Submissions Report
New High School in Bungendore
SSD-14394209

On behalf of
NSW Department of Education
September 2022

This Submissions Report has been prepared by Mecone NSW Pty Limited on behalf of the NSW Department of Education to support the proposed new high school in Bungendore (SSD-14394209).

AR DA HS -1010

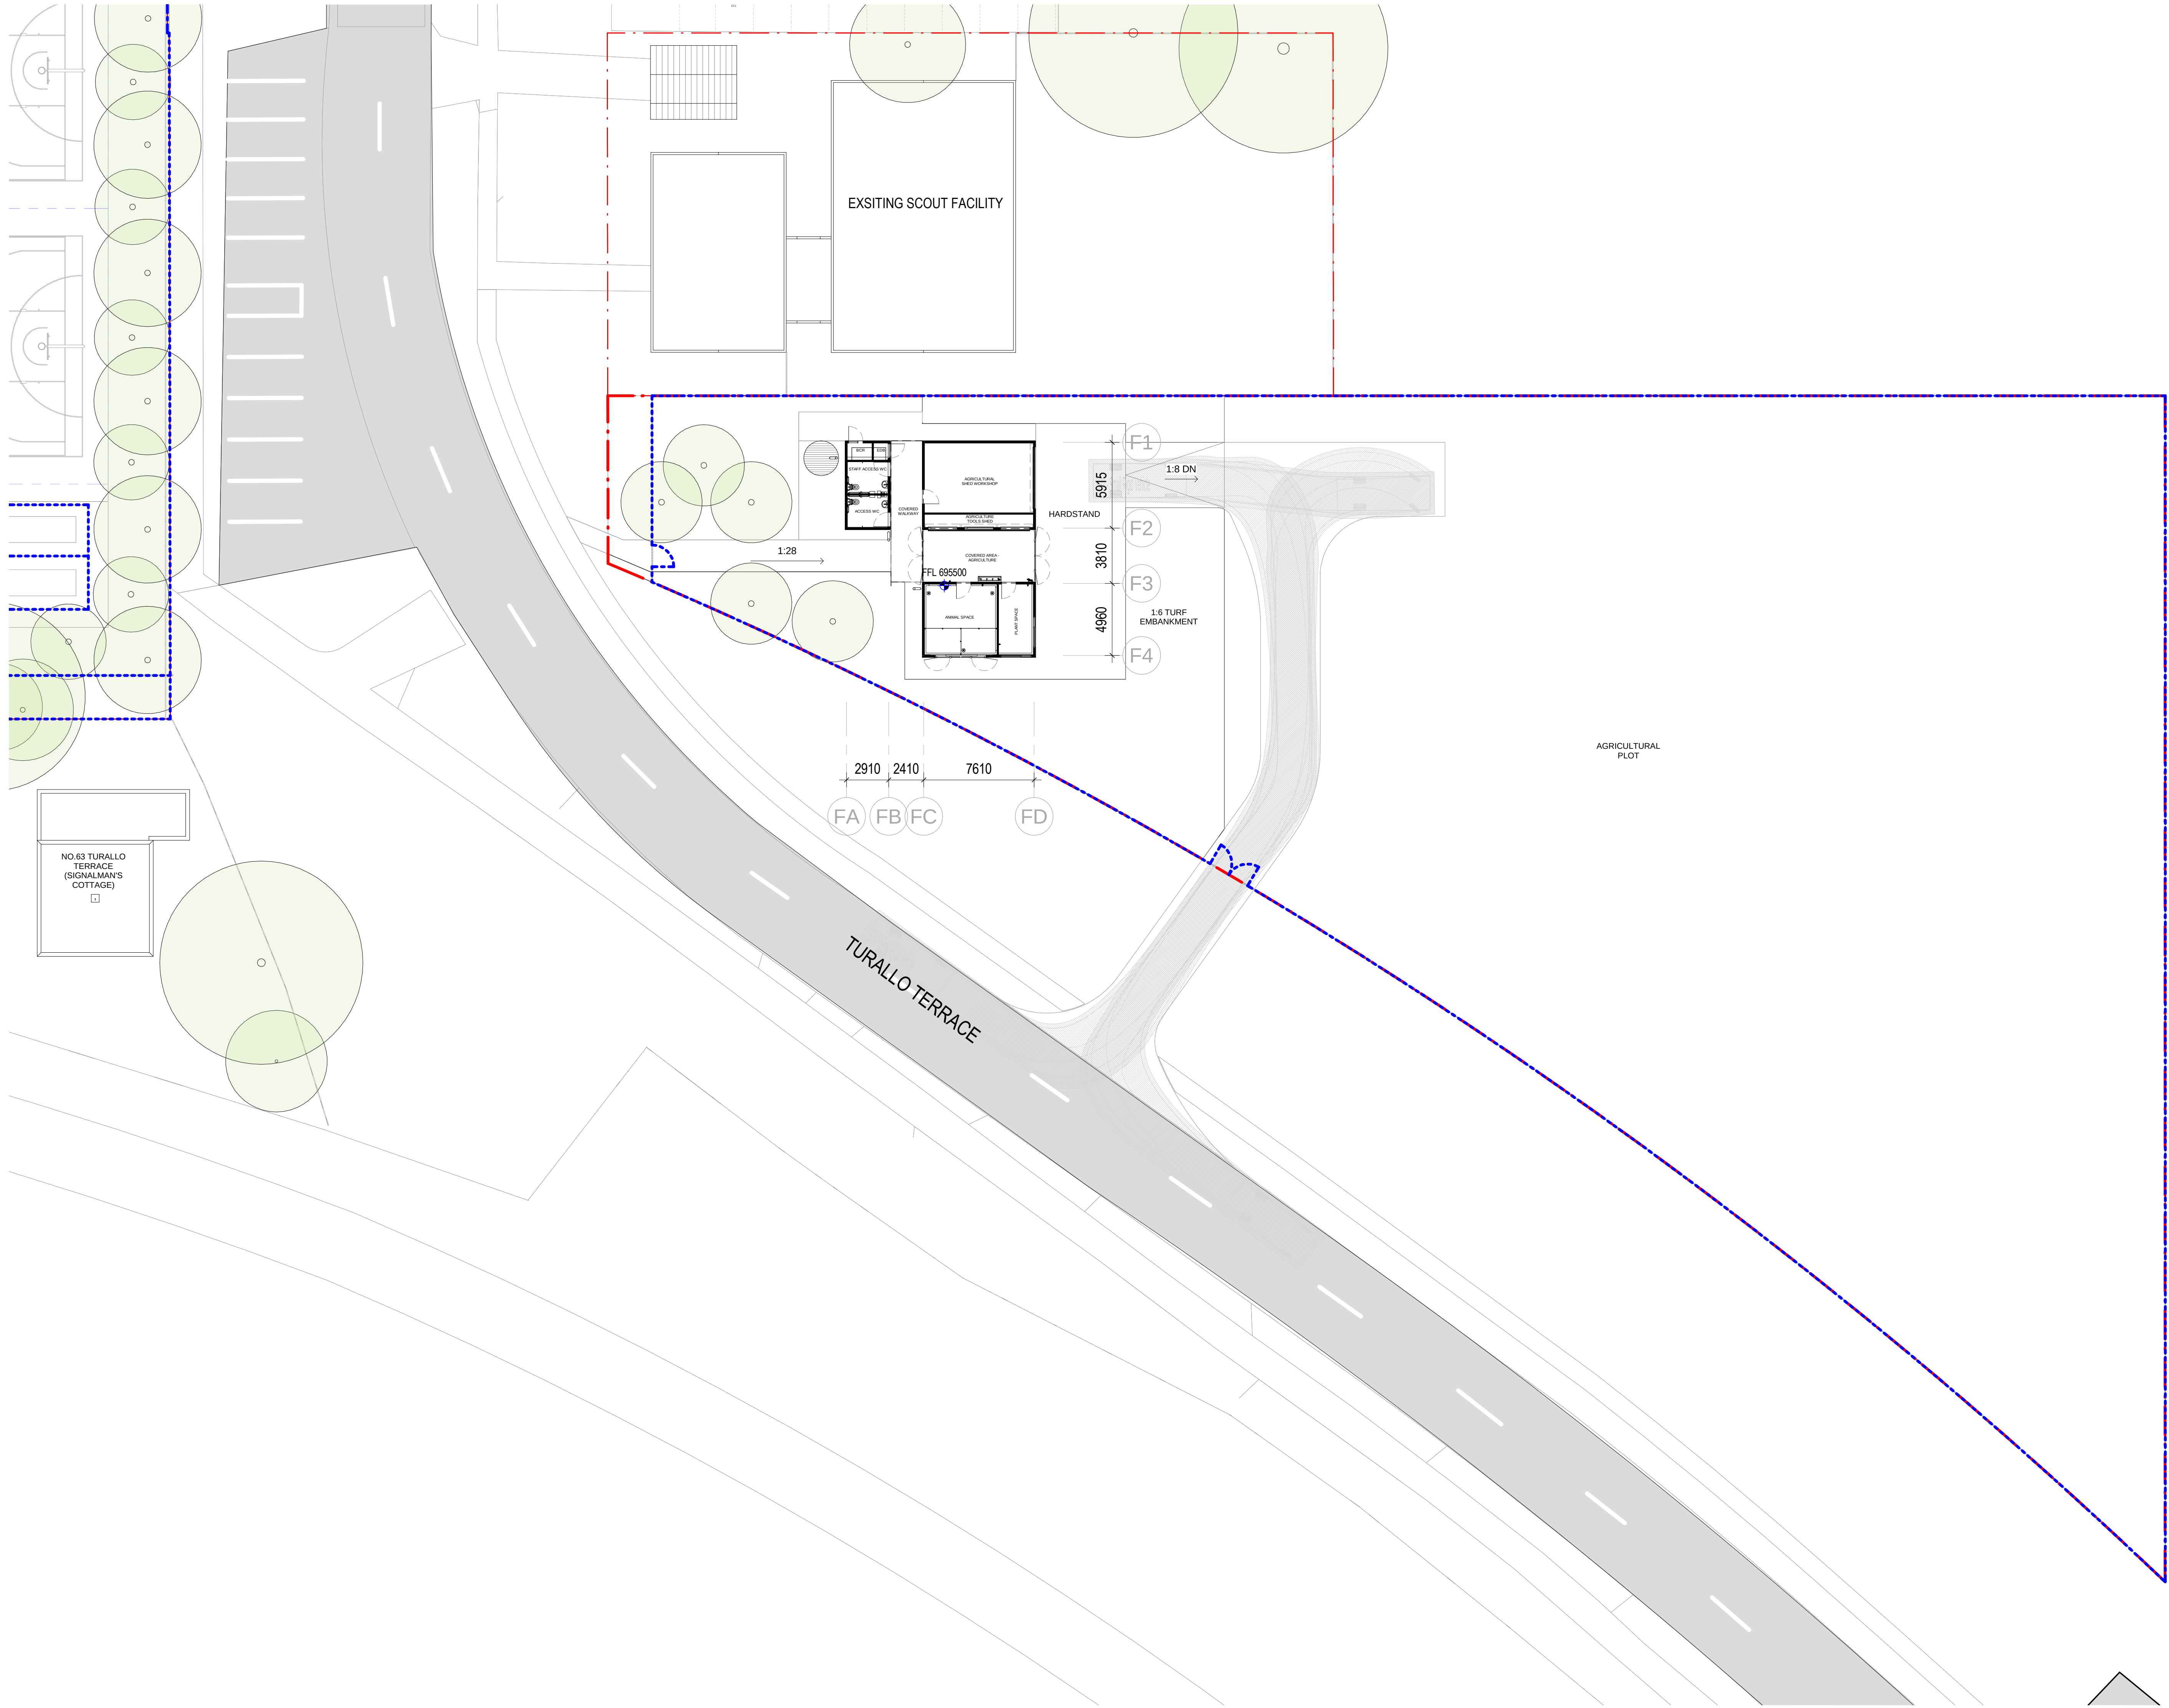
Amended Layout

- Amendment to the layout and design of the school buildings including relocation of buildings and sporting facilities, reducing bulk and scale, amending the colours and finishes, and removal of the community facilities which are being provided by Council through a separate planning process on a separate site.

- The original alignment of Majara Street has been reinstated within the revised design. The built form and landscape design have been amended to acknowledge and reinforce the original street alignment. The relocation and redesign of the built form from the Majara Street axis retains the site's existing visual connection with Turallo Creek to the north.
